Permit Number: 050293

has permission to Adding bathrooms and office

AT 238 Riverside St

RE: Bradco/Wickes Renovations
235 Riverside Street

PHASE ONE RENOVATIONS
BRADCO / WICKES SUPPLY CORP.
 235 RIVERSIDE ST PORTLAND, MAINE
 JOB TITLE

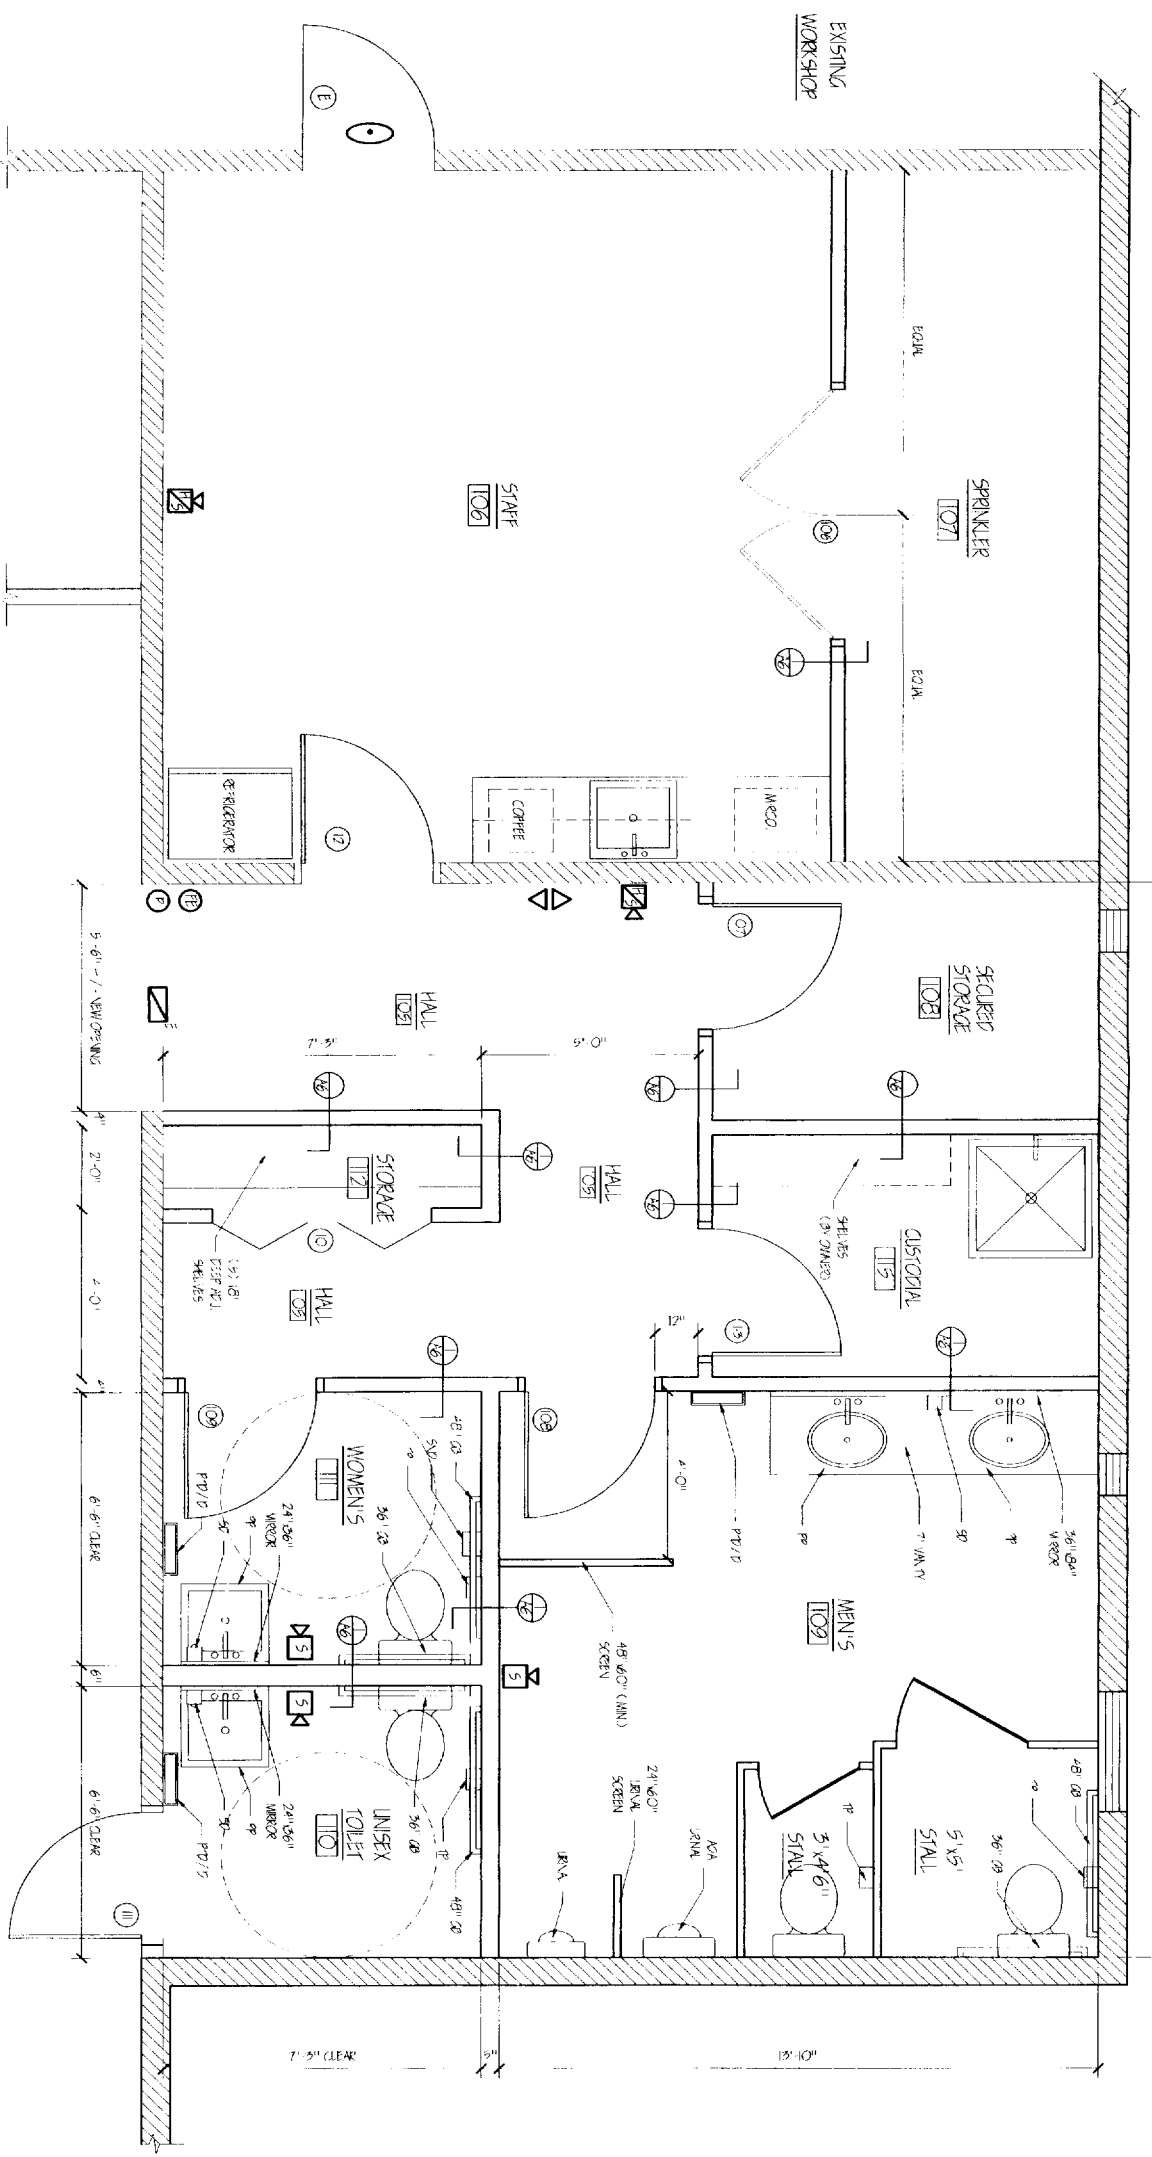
4/13/2005-mjrn: Plans show wooden studs...must be steel in type 2 construction, **NEW PLANS DROPPED OFF**

4/13/2005-mjn: Plans show wooden studs....must be steel in type 2 construction

We have removed **all** notes referring to wood framed interior partitions and have changed the framing system for these partitions to metal studs per your request based on the building's construction type (Type IIB).

We will send a copy of the revised drawings (Sheets A5 & A6) via **mail** this week.
